Application Reference Number:	2025/0599
--------------------------------------	-----------

Application Type:	<i>Tree Preservation Order (TPO).</i>
--------------------------	---------------------------------------

Proposal Description:	<i>Remove Ash tree T1 and Crack Willows T13 and T14, remove eastern stem and crown reduce remaining crown by 2-3m Goat Willow T4 and crown lift Cherry laurel T9 and G16 to 2.5m within TPO 5/2004.</i>
Location:	<i>4 Mysten Croft, Barnsley, S75 1EP.</i>

Photo 4: Suggested reduction of T4 following removal of eastern stem

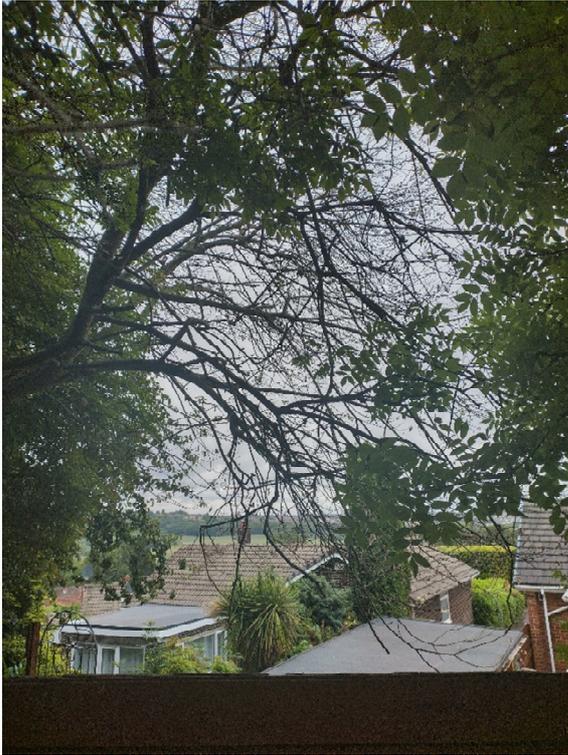
It is also proposed to remove the dead/dying eastern stem of a Goat Willow (T4) and then crown reduce the remaining two stems by 2-3m. The removal of the eastern stem is required and as such the reduction of the other two, despite not generally being considered desirable, is sensible in this instance given the loss of companion shelter through the removal of the eastern stem. The reduction works would likely reduce the stresses from wind on the tree and give it the best chance to recover and adapt to the loss of the eastern stem.

Tree Plan

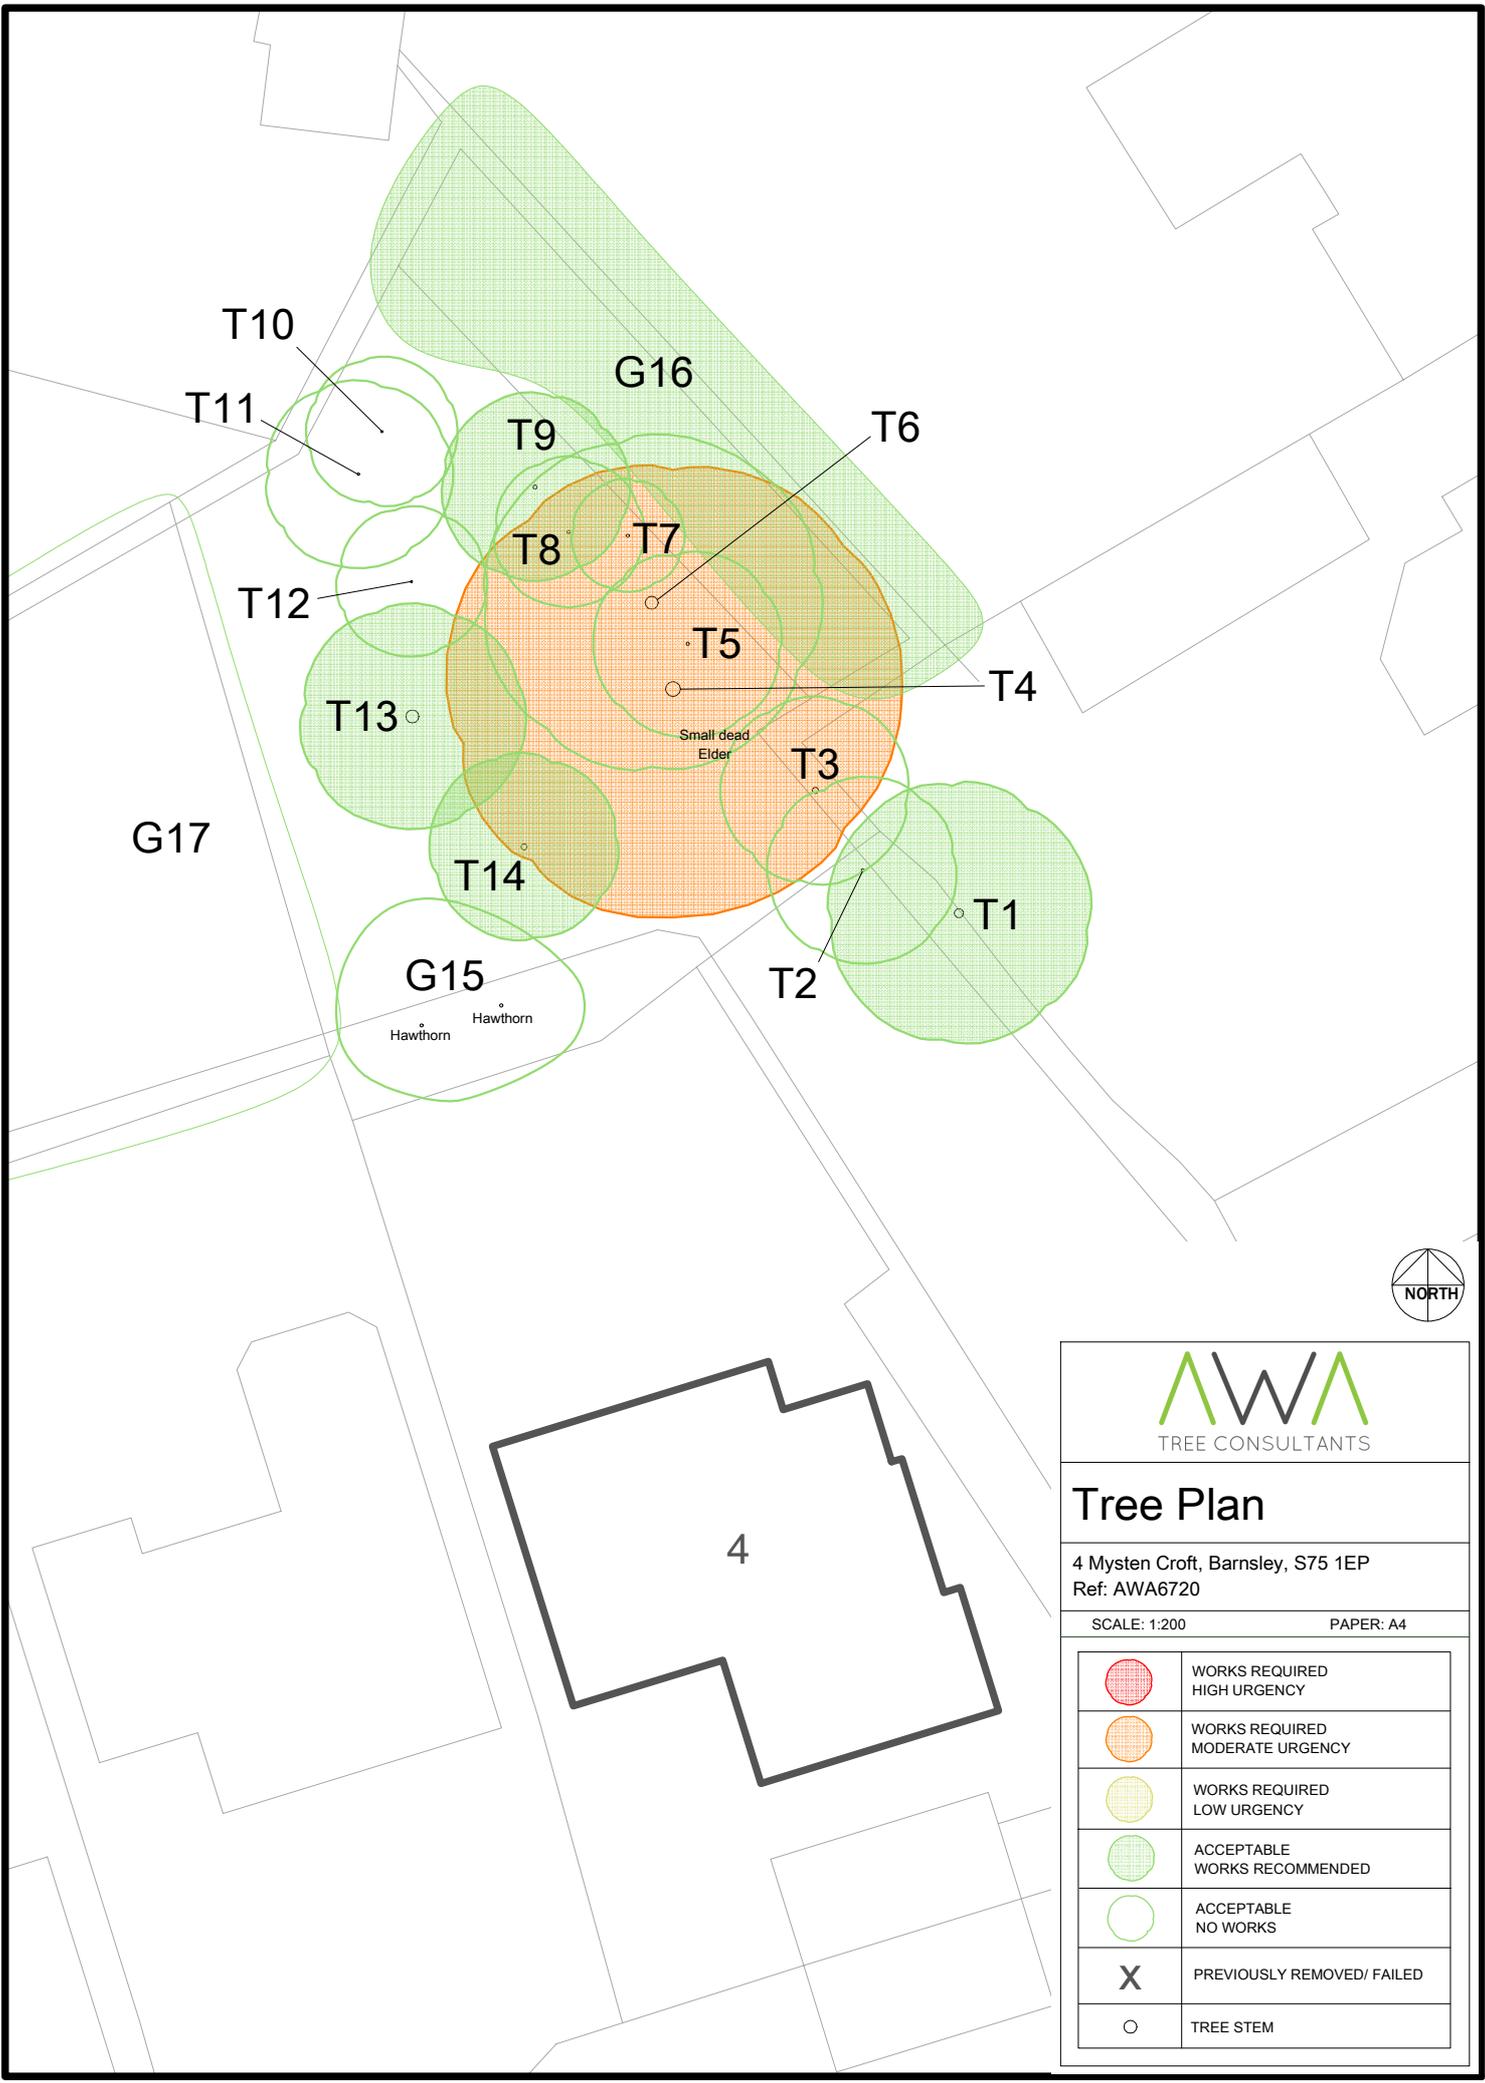
The trees to be removed are a young Ash tree (T1) and two dilapidated Crack Willows (T13 and T14). The young Ash tree is a self-set specimen which is located on top of a retaining wall above a neighbouring property and based on the visual inspection of the Council's Forestry Officer, it is evident that there is ground movement around this tree and that it appears that the land is beginning to slip. As such, the Council's Forestry Officer raised no objection to the removal T1 as the ground movement and level difference ultimately limit the trees retention span.

The two Crack Willows are considered poor specimens that have been poorly managed in the past. Ultimately, the Council's Forestry Officer considers that the nature of this species makes these trees unsuitable for this environment, and when coupled with their generally poor condition, the removal and replacement of T13 and T14 is considered a sensible option.

It is also proposed to prune Cherry Laurel (T9) and a mixed group (G16) by crown lifting them to 2.5m to allow clearance and access under the canopies. The Council's Forestry Officer has raised no objection to the undertaking of this work as it is considered sensible maintenance.

The three trees being removed will need to be replaced, and given the constraints of the application site, it is considered sensible to replace them with small to medium-sized native trees. Two new Silver Birch trees and a new Rowan tree have been specified.
